Subject: RE: Attached letter from Kirklees Council regarding application number 2025/93435 at location Land off, Blackmoorfoot Road and Felks Stile Road, Crosland Moor, Huddersfield, HD4 7AD

Further to a review of the additional information provided, I would like to advise the following:

S104 - Drainage Details Sheet 2 of 3

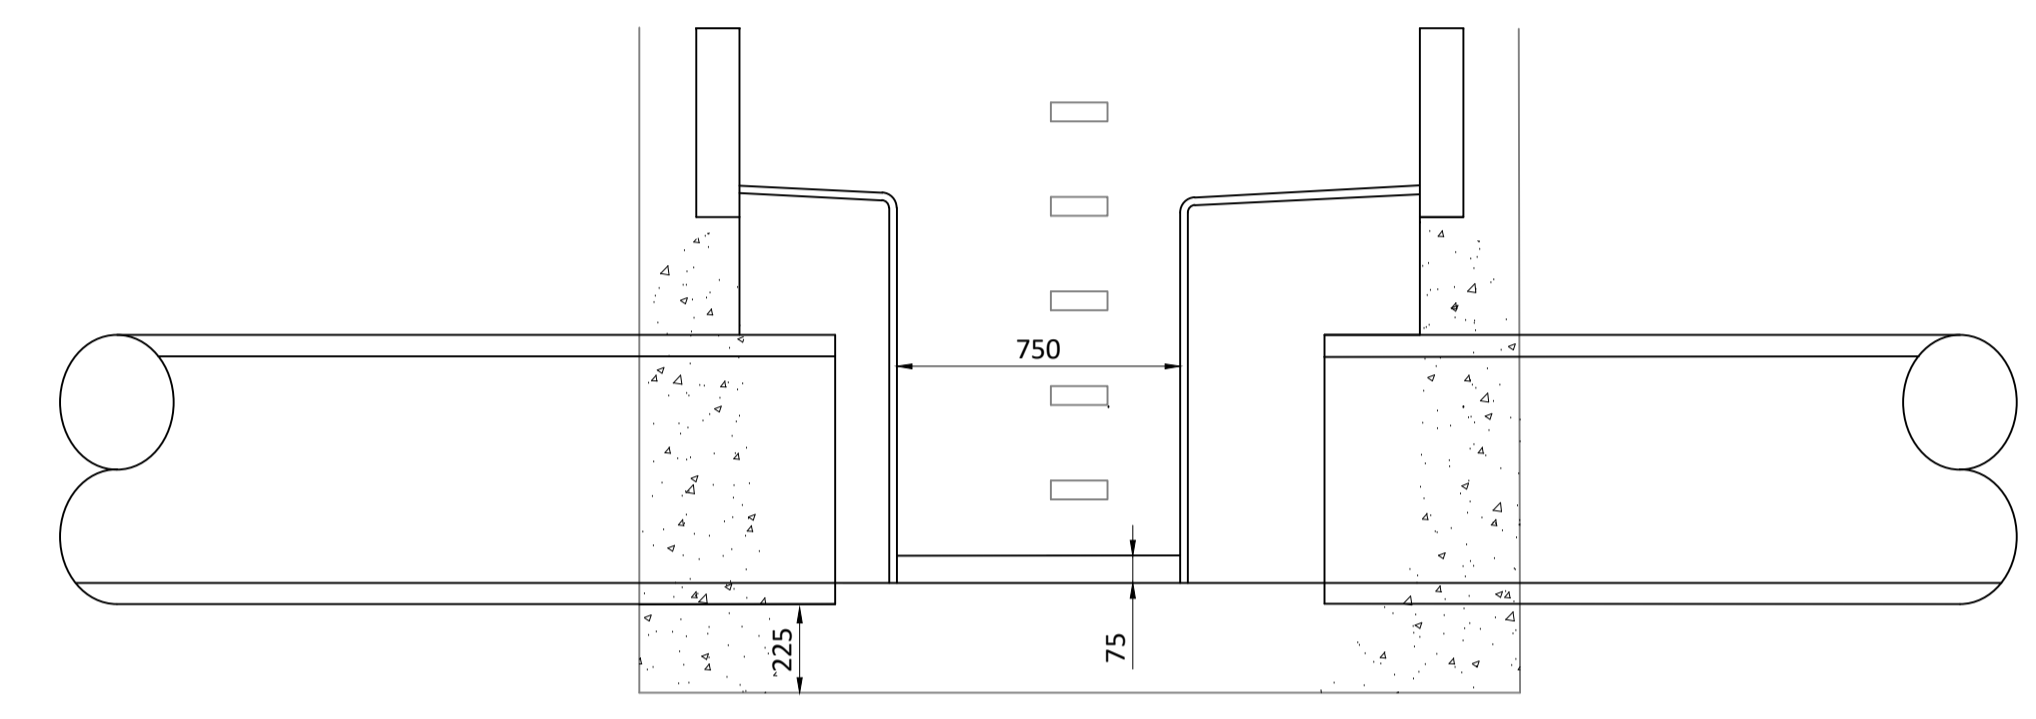
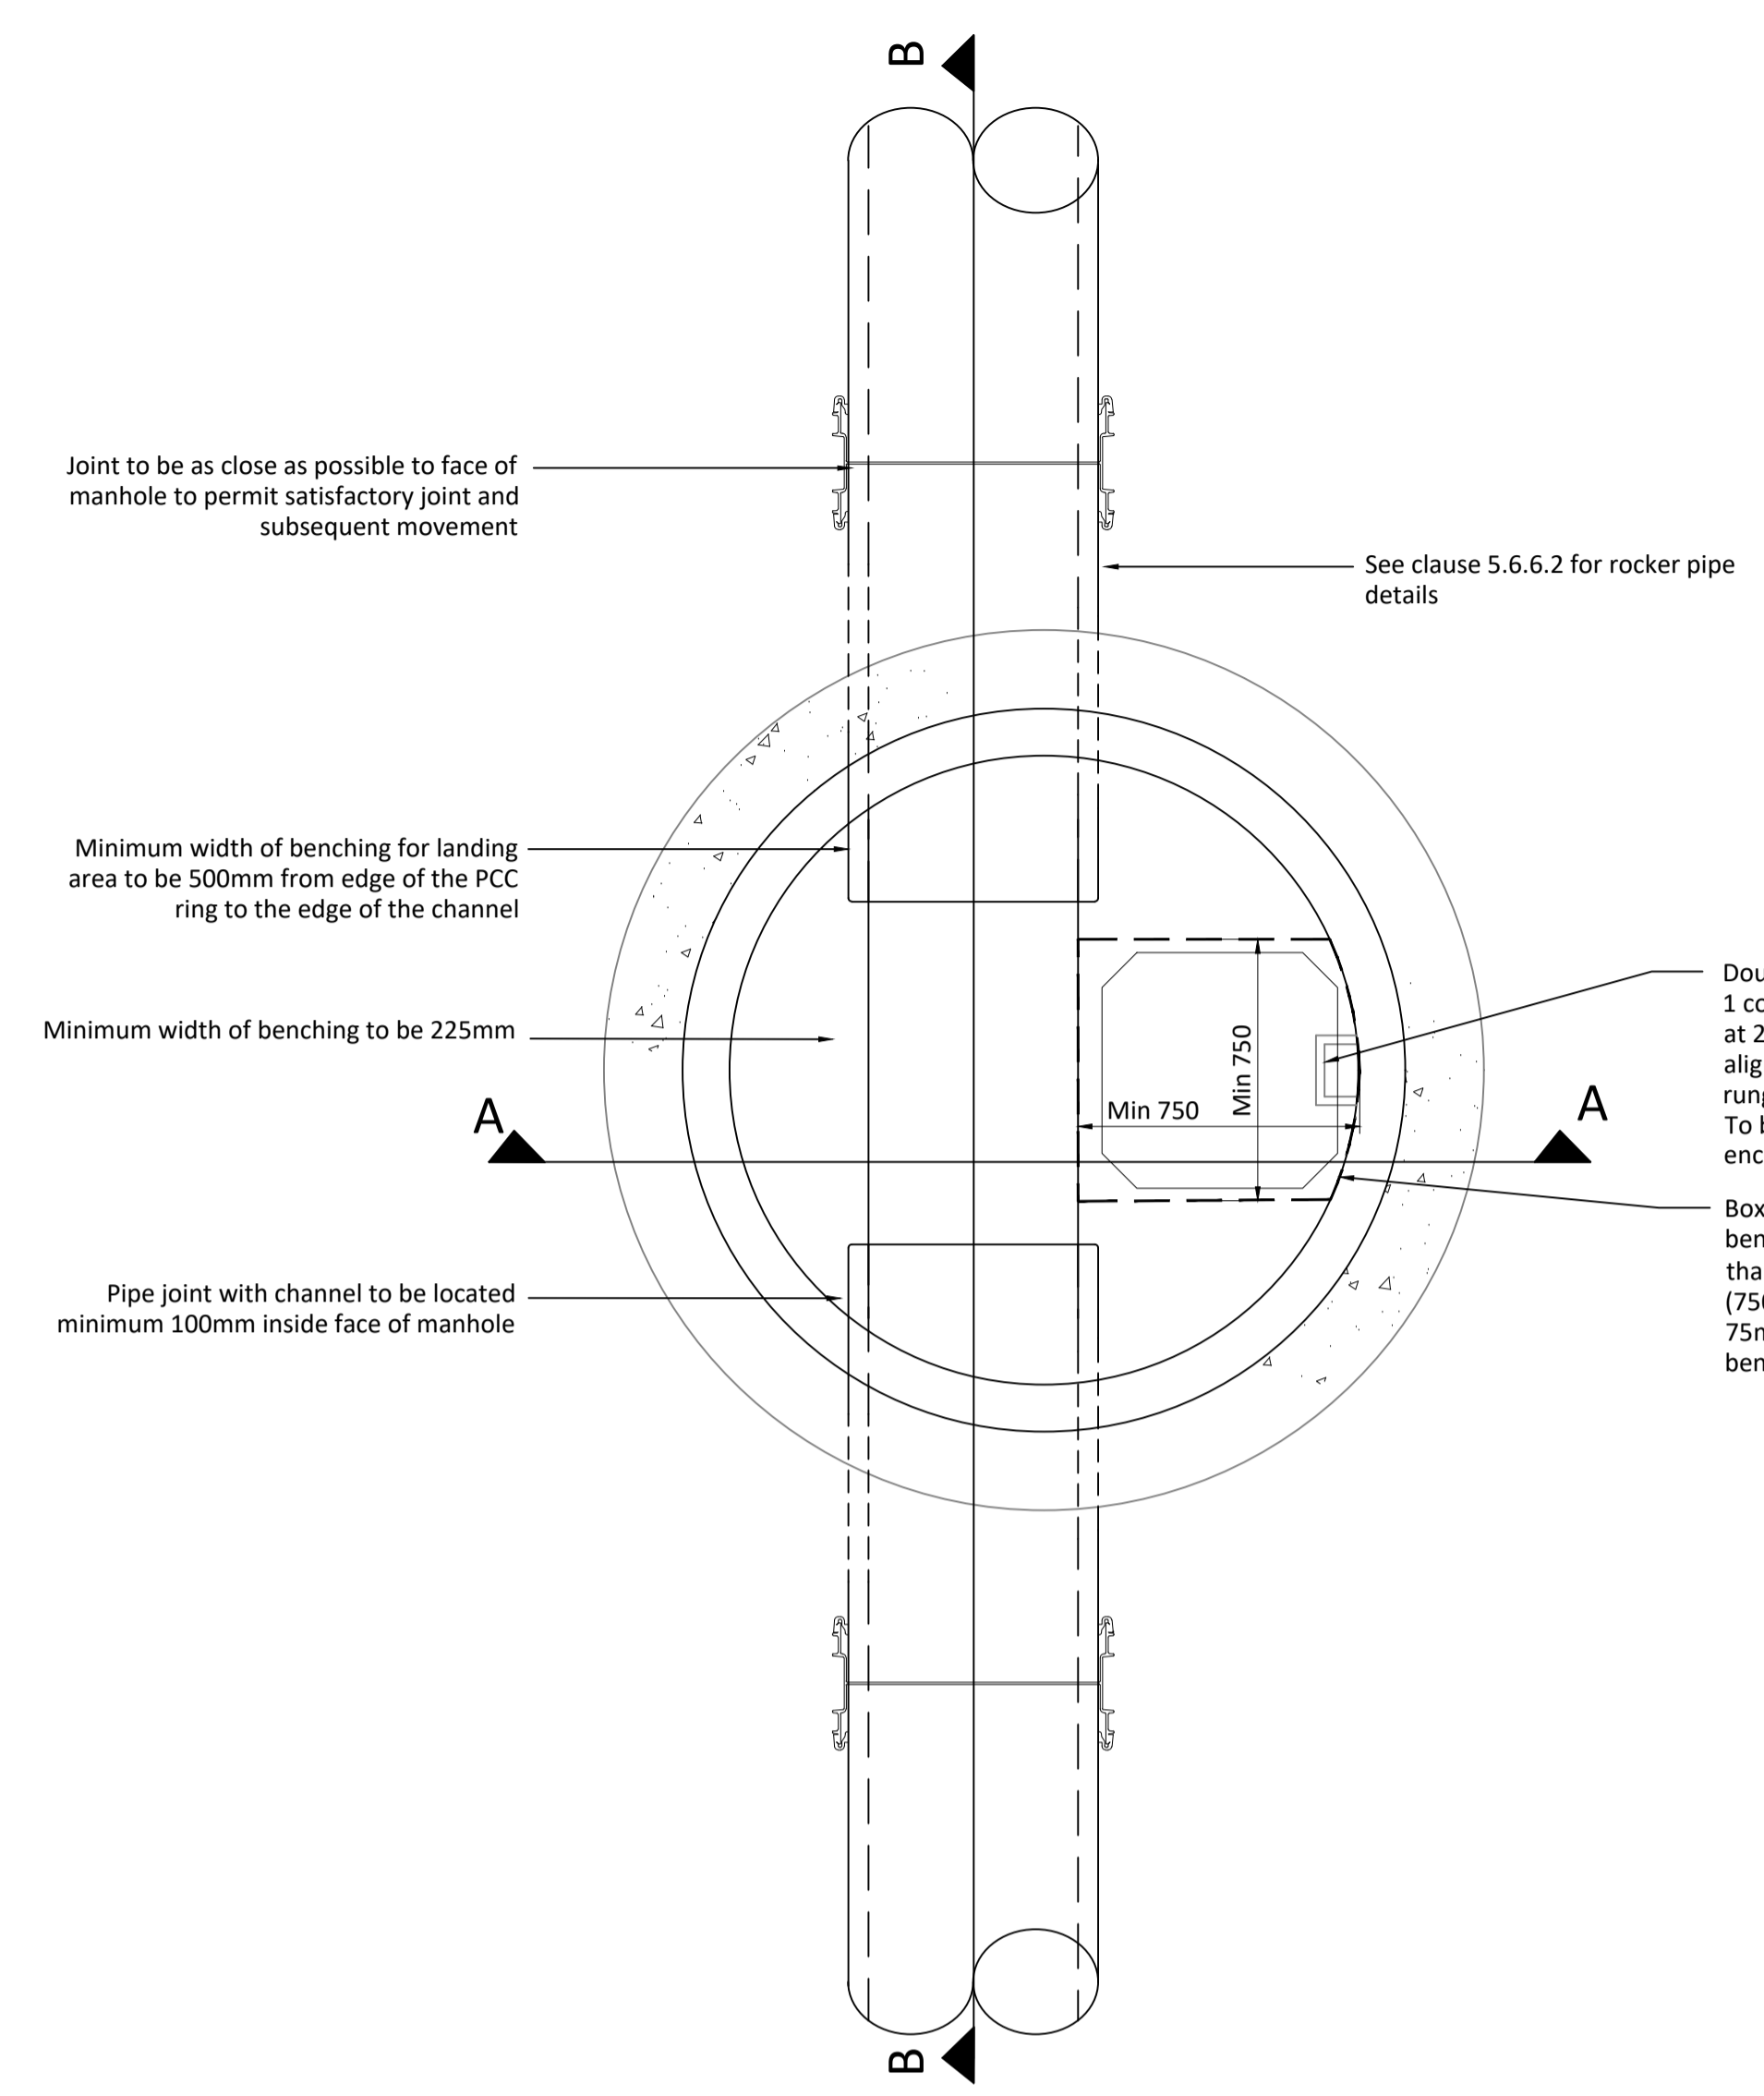
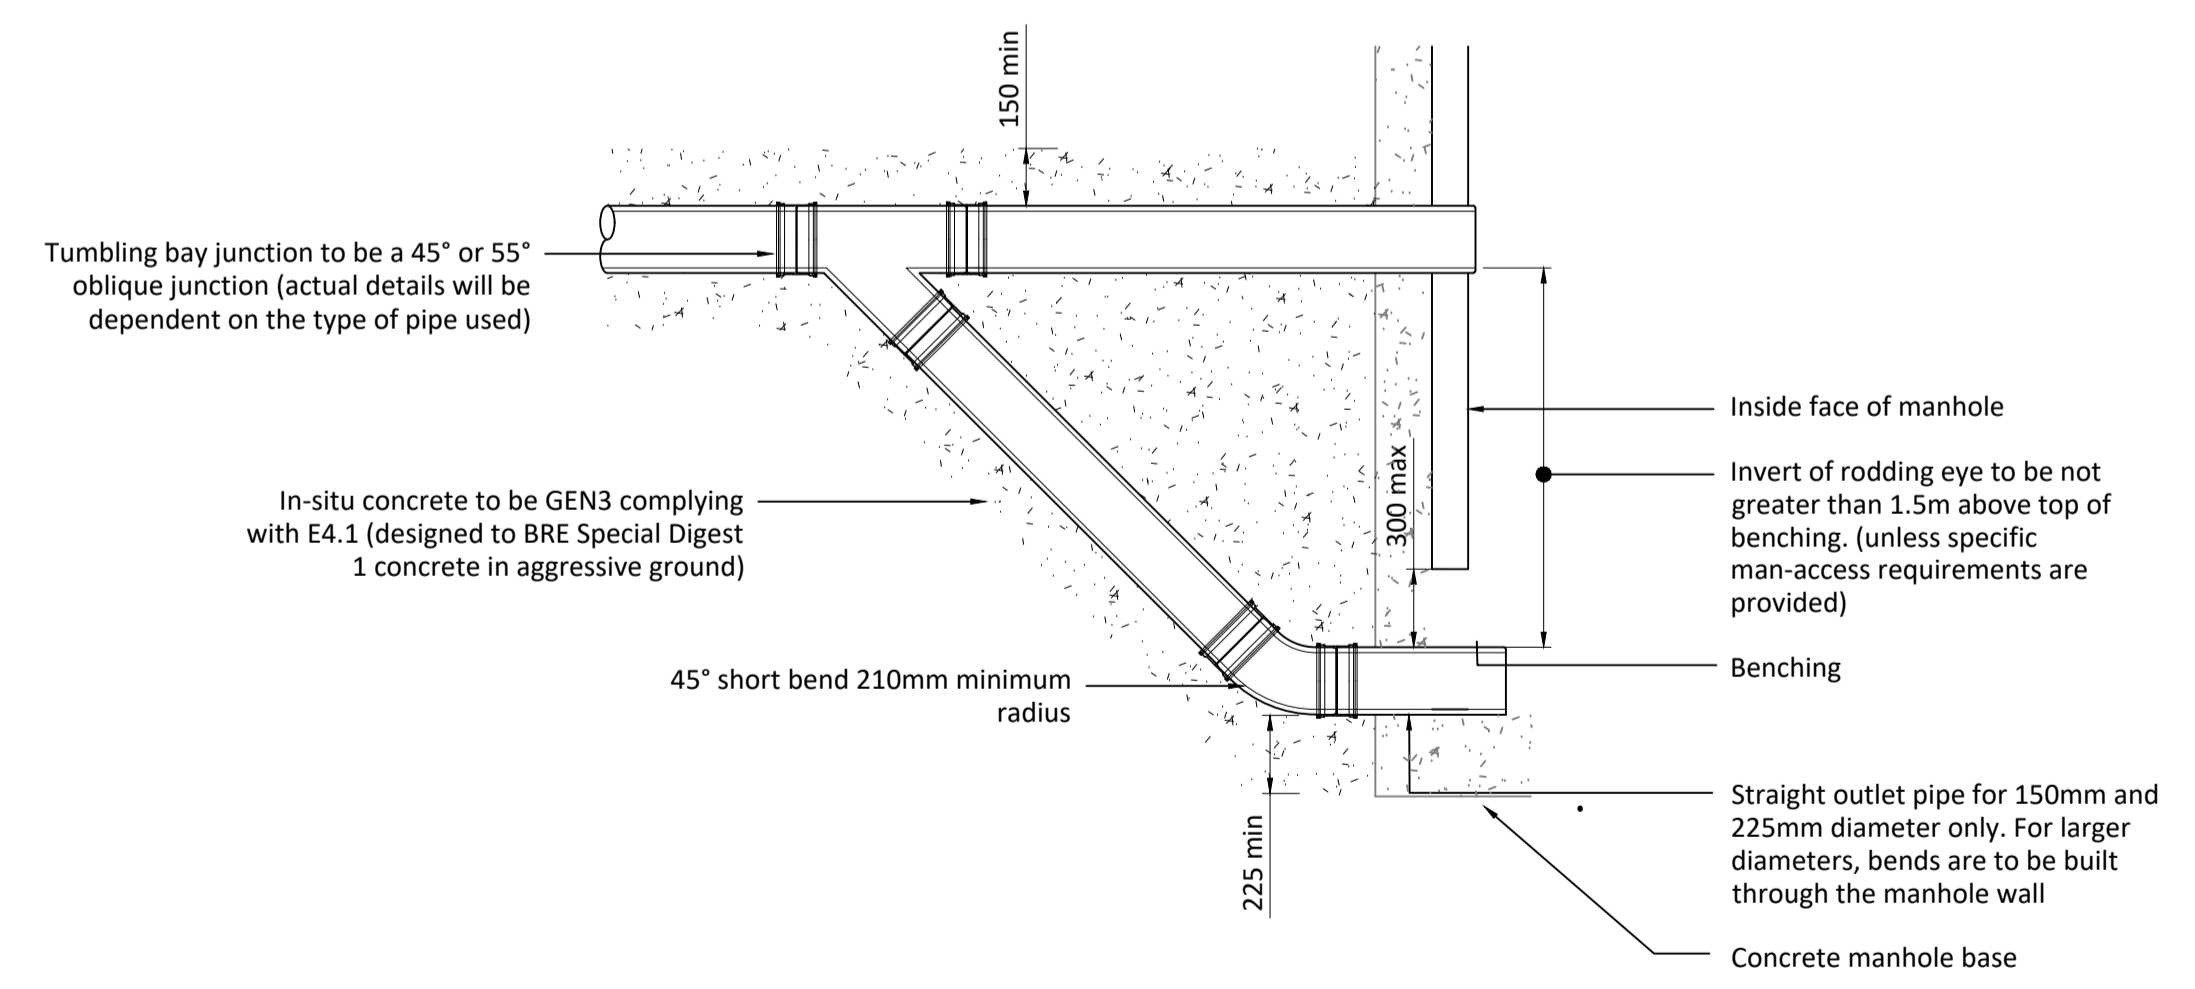
Condition 17 (surface water attenuation in highway)- This condition can not be discharged pending the submission of a manhole schedule for the proposed surface water drainage system installed in the highway. In addition, it should be noted that this comment is based on drainage drawings produced by ADEPT and not ARP drawings which are understood to have been superseded and as such should be moved elsewhere.
